Technical note

Project name	Buxton House		
Design note title	HSE Comments		
Document reference	22176-HYD-XX-XX-RP-FE-1002		
Author	Annie Flores		
Revision	00		
Date	12 June 2024	Approved	✓

This technical note addresses comments received from the Health and Safety Executive (HSE) on 03.05.2024 (reference pgo-5084) for the Buxton House project in Huddersfield, with regards to fire safety only.

Drawing Number: **22176-HYD-XX-00-DR-FE-1001**      Revision: **02**

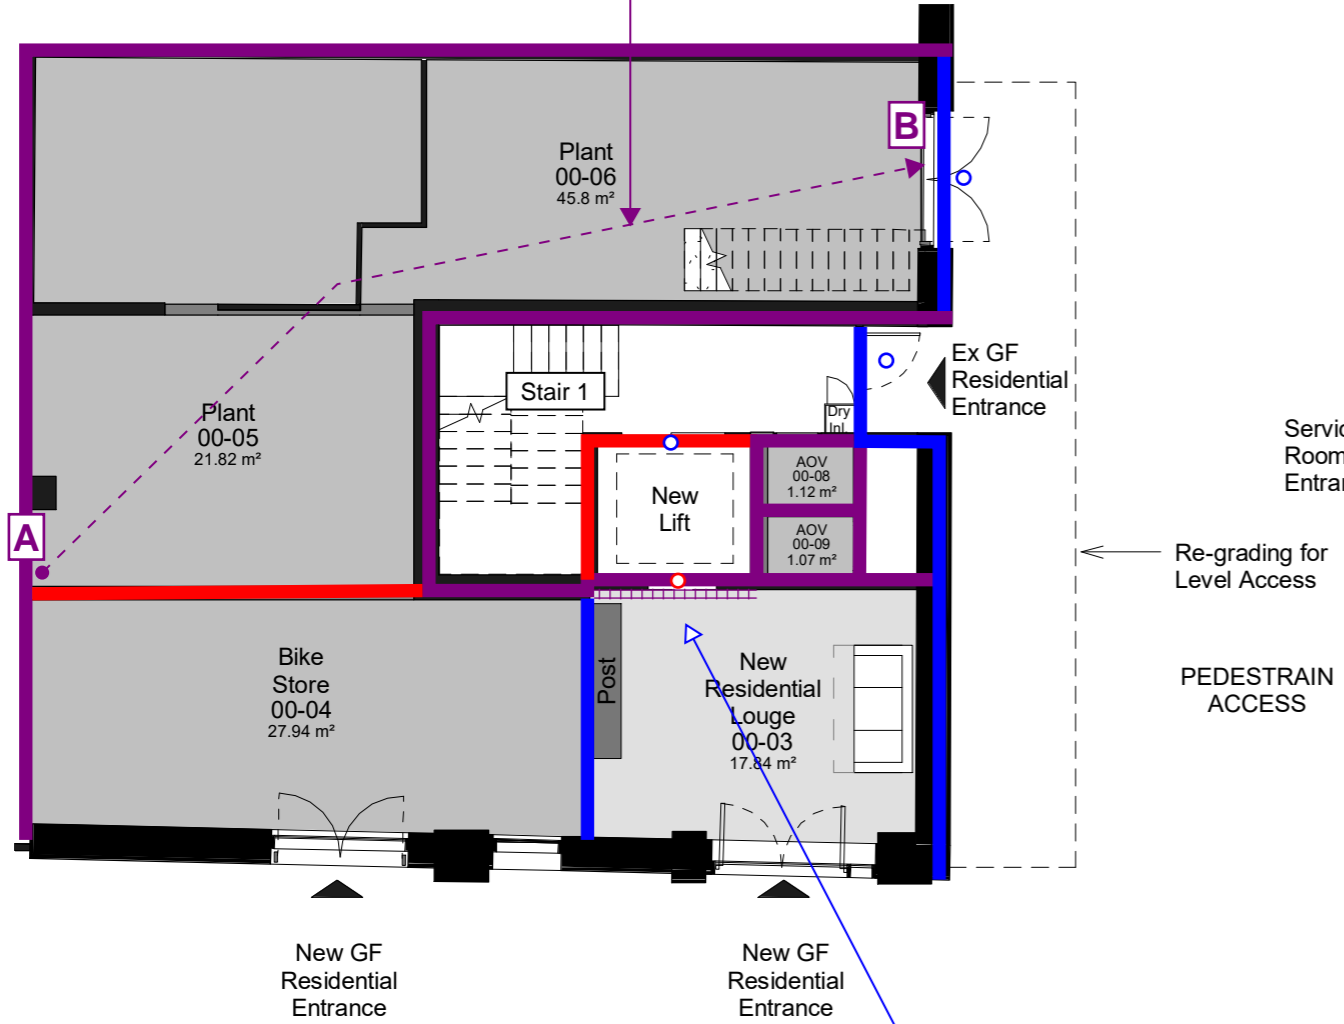
- 2.4 Noted. Please refer to Section 7.2.2/7.2.2.1 of the fire safety strategy report (document reference 22176-HYD-XX-XX-RP-FE-1001, Rev.04) for commentary on the dual-entry lift opening located within the firefighting stair core at ground floor. As part of the fire strategy proposals, a 120-minute fire and smoke curtain is to be provided to the lift on the entrance lobby side, so as to afford protection of smoke ingress into the lift shaft/stair.
